Fwd: Urgent comments please - One Joy Place

From: **Jeff Tarling** <jst@portlandmaine.gov>
Date: Wed, Sep 20, 2017 at 4:43 PM
Subject: Re: Urgent comments please - One Joy Place
To: Jean Fraser <jf@portlandmaine.gov>

I have reviewed the landscape plan for the proposed One Joy Place project.

LANDSCAPE PLAN

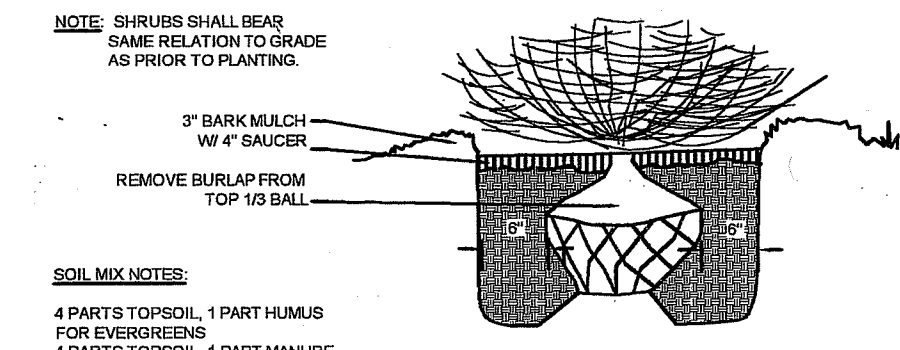
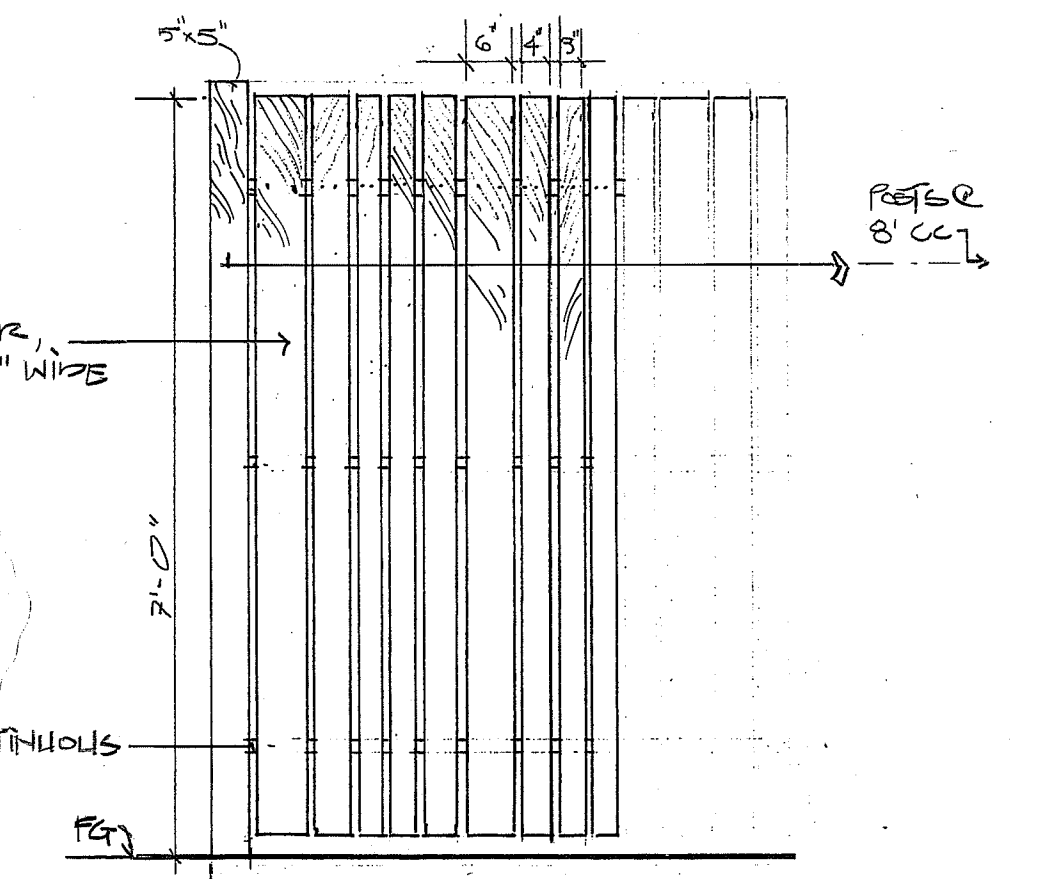
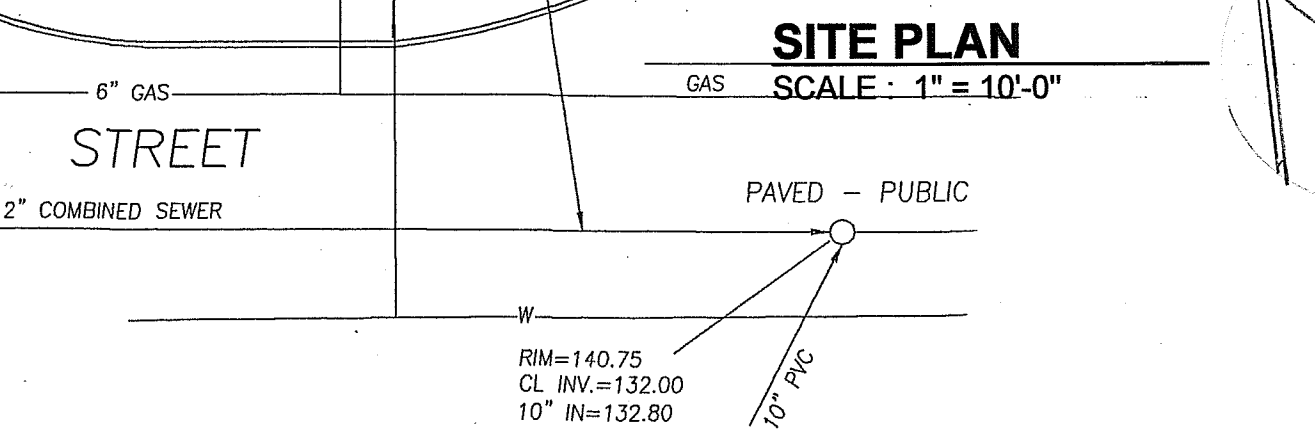
The project does have landscape challenges due to its unique site location and lack of street frontage. One suggestive comment would be to find a substitution for the Amur Maple as they tend to show up on the invasive plant list. Other suggestions might include 'Cornus mas', Hop Hornbeam, Cornelian Cherry Dogwood.
